**WELWYN HATFIELD BOROUGH COUNCIL
EXECUTIVE DIRECTOR - PLANNING, PUBLIC PROTECTION AND GOVERNANCE**

DELEGATED APPLICATION

Application No: 6/2017/2297/LAWP
Location: 9 Theobalds Close Cuffley Potters Bar EN6 4HH
Proposal: Certificate of lawfulness for the erection of a ground floor extension and studio annexe following demolition of existing lean-to garage
Officer: Ms Lucy Hale

Recommendation: Refused

Drawing Title:  
 Proposed Side and Rear Extensions  
 Proposed Elevations

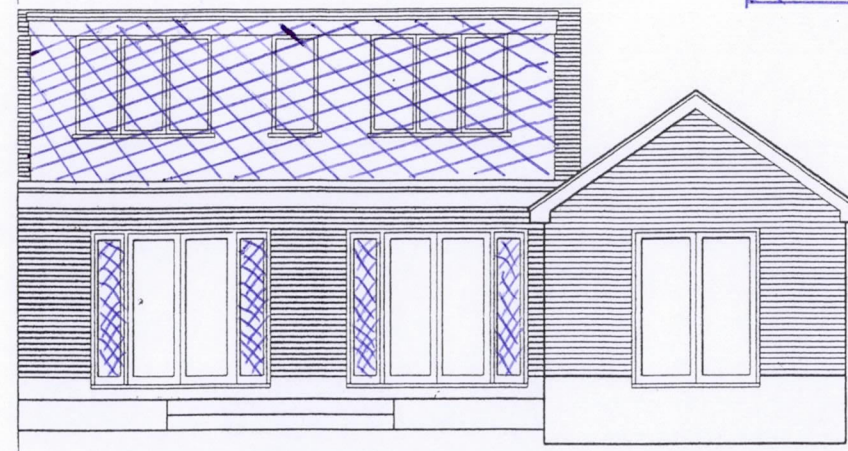
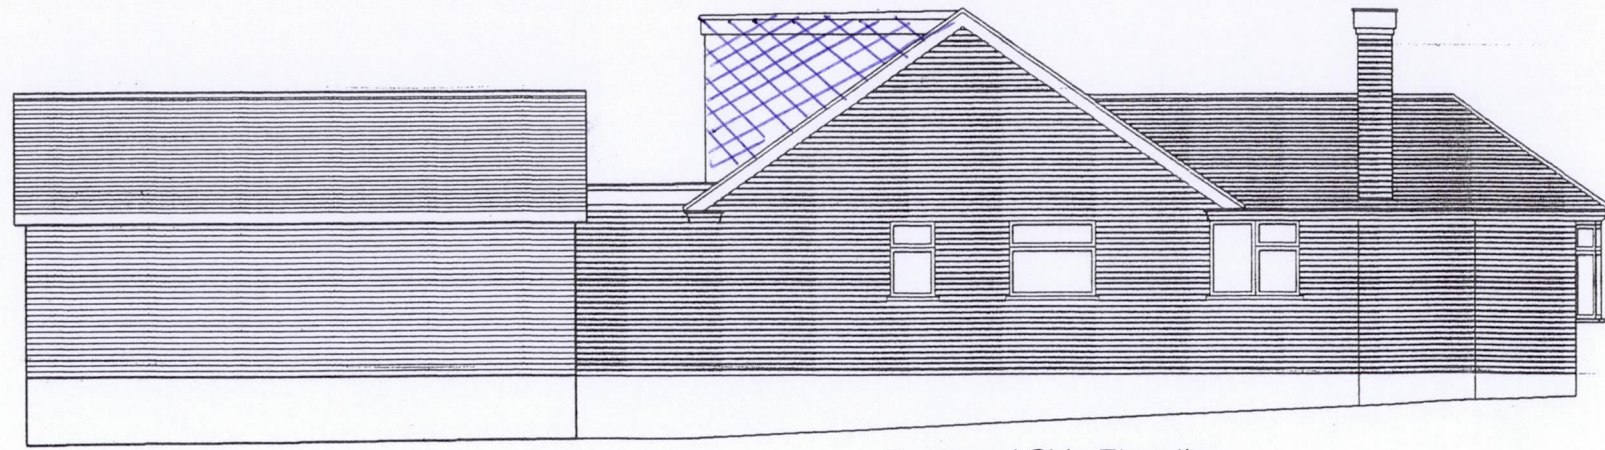
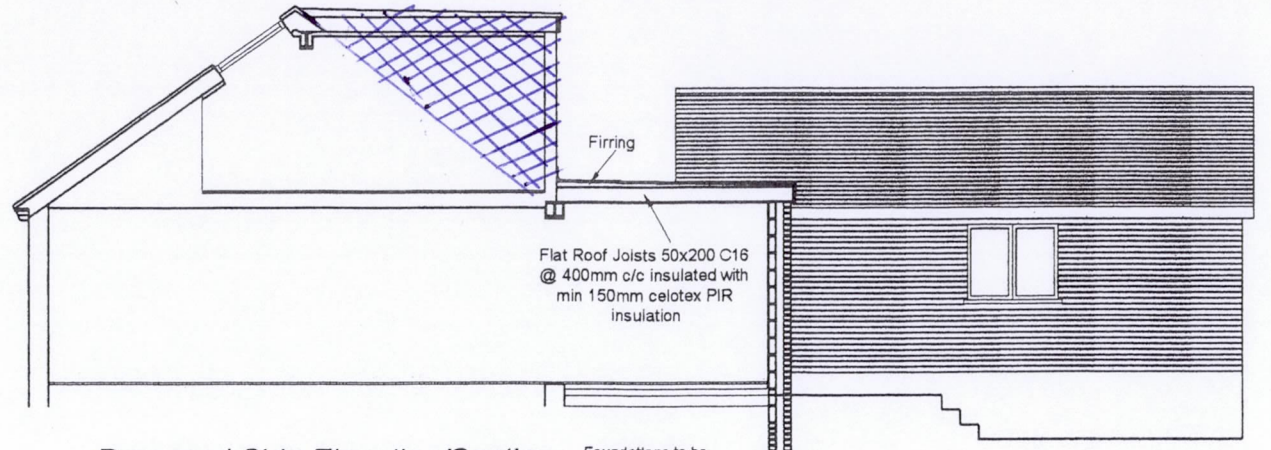
(f) would, subject to paragraph (g), the enlarged part of the dwellinghouse would have a single storey and— (i) extend beyond the rear wall of the original dwellinghouse by more than 4 metres in the case of a detached dwellinghouse, or 3 metres in the case of any other dwellinghouse, or (ii) exceed 4 metres in height	Y 9.6 M in total Y 4.7 m	N
until 30th May 2019

The proposed development follows a recently granted planning application under reference S6/2014/0563/FP for single storey rear extensions and rear dormer. The plans submitted for the certificate are the same as those granted under the planning application for the rear extensions although the applicant outlines that the dormer is no longer included in the scheme. The proposal extends further than 8 metres off the original rear wall and exceeds 4m in height thus failing to comply with Schedule 2, Part 1, Class A (f).

The extension also falls within 2 metres of a boundary with the eaves height exceeding 3 metres thereby failing to comply with Schedule 2, Part 1, Class A (i).

The extension further extends beyond a wall forming a side elevation of the original dwellinghouse and has a width greater than half the width of the original dwellinghouse and thus fails to comply with Schedule 2, Part 1, Class A (j)

The proposal fails to comply with the Town and Country (General Permitted Development) (England) Order 2015 by virtue of the proposed development extending beyond the rear wall of the original dwellinghouse by more than 3 metres and exceeding 4 metres in height, falling within 2 metres of a boundary with the eaves height exceeding 3 metres and extending beyond a wall forming a side elevation of the original dwellinghouse and having a width greater than half the width of the original dwellinghouse. As such the development is not deemed to be lawful. Certificate of Lawfulness is therefore refused.
